Draftline Services

Reference; Proposed Dormer Bungalow to rear of 2, St. Lukes Way, Monk Bretton,
Barnsley S71 2HB for Mr M.Bloomfield. App No 2010/0002

Yorkshire Water Sewer within 3metres ref; L000118 dated 28th January 2010

DATE	OCTOBER 2009	PROPOSED DIVISION OF PLOT AND BUILDING OF DORMER BUNGALOW & DETACHED GARAGING AT 2 ST LUKES WAY MONKBRETTON BARNSELY S71 2HB FOR MR. M. BLOOMFIELD.
SCALE	1:100	
DRAWING NO	03/FP/10/09P	
REVISIONS		
A

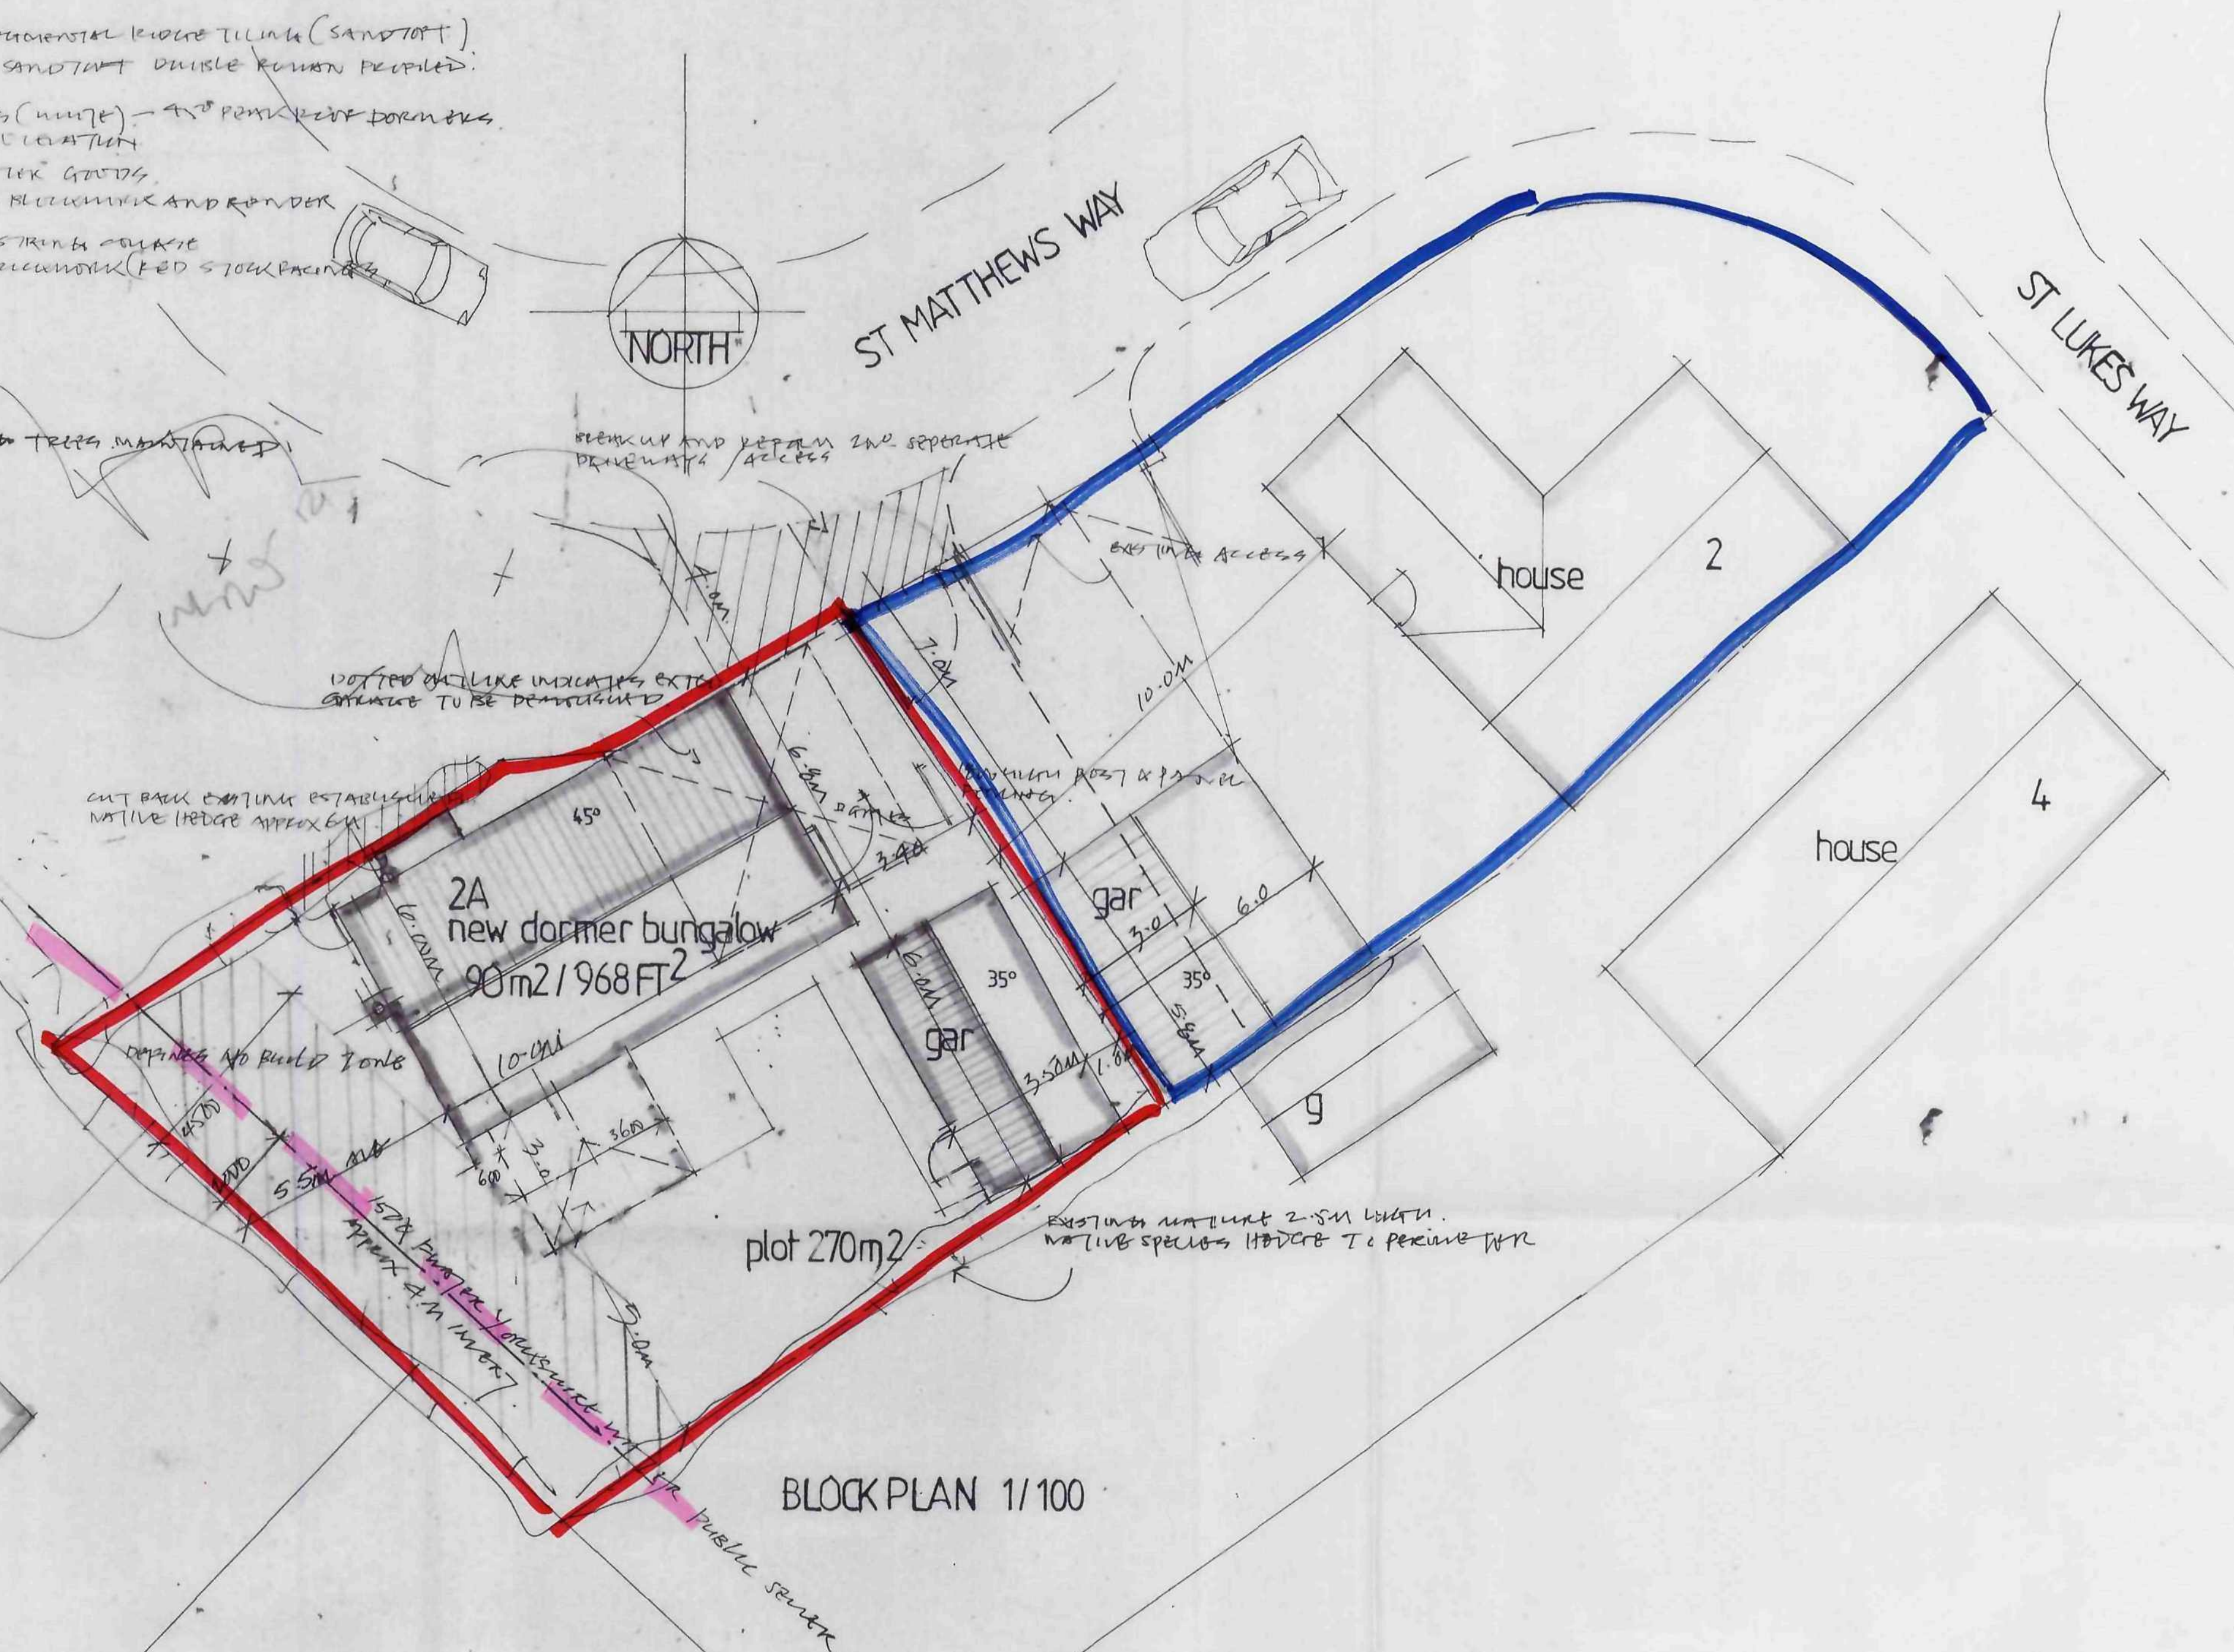
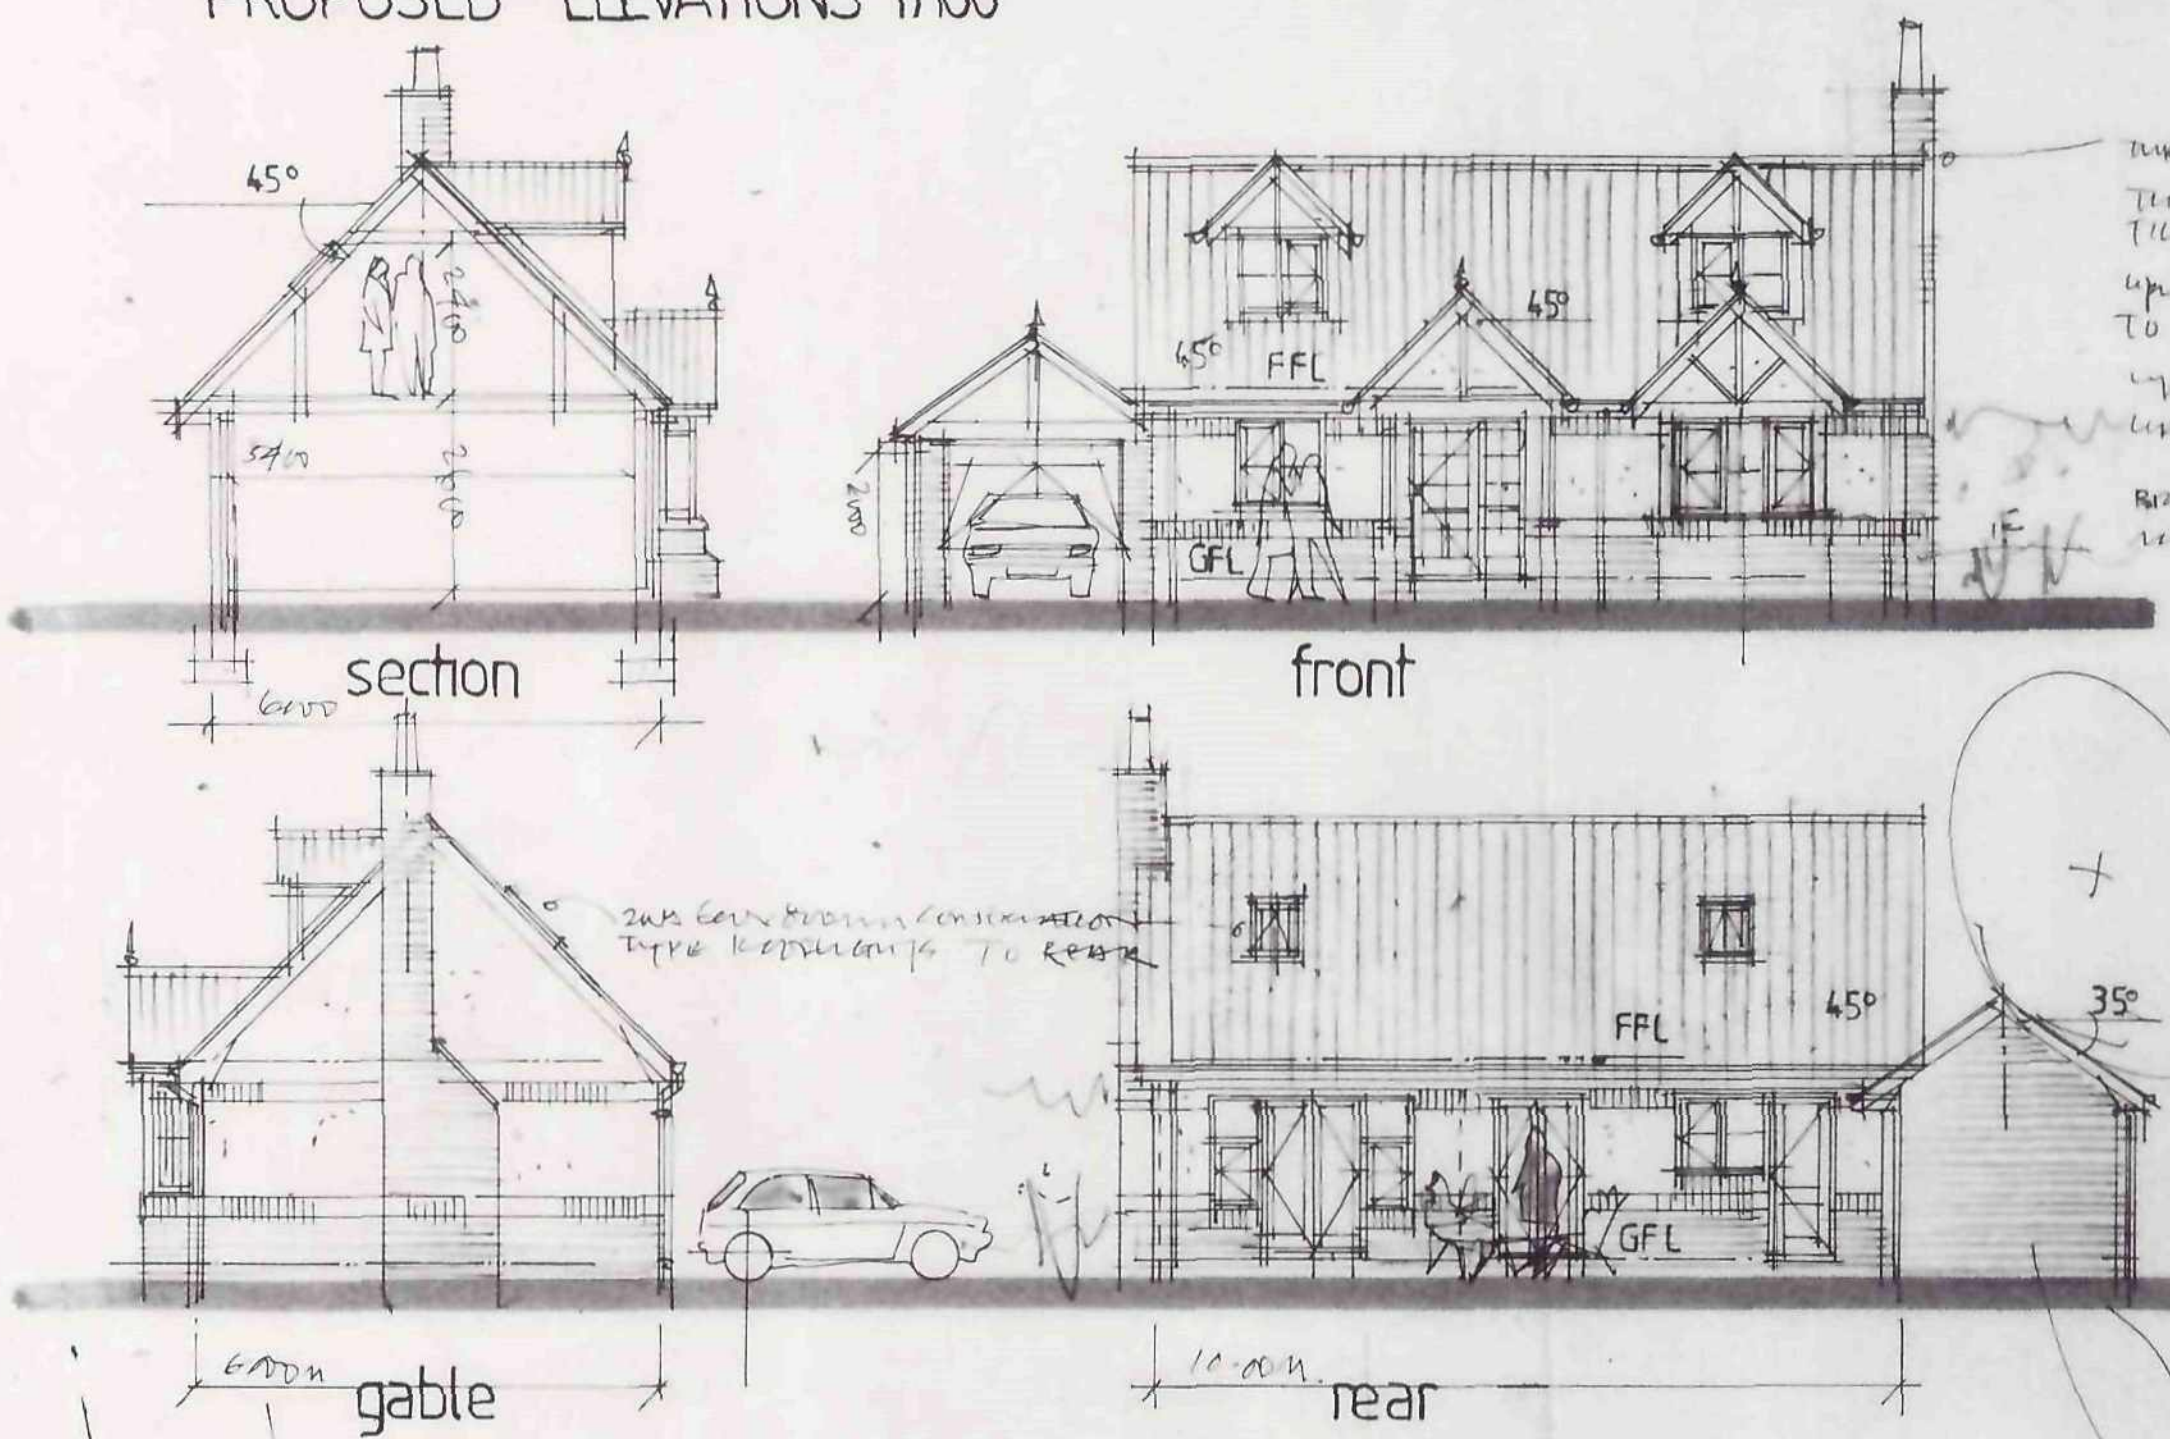
Please find for your comment and file ;position sive of sewer crossing the rear of the above site @ approx 4m depth.

Corrective Foundation design being to build the proposed Bungalow on a concrete raft or beam and pile construction and therefore not causing any further positive loading to the 150 dia foul sewer.
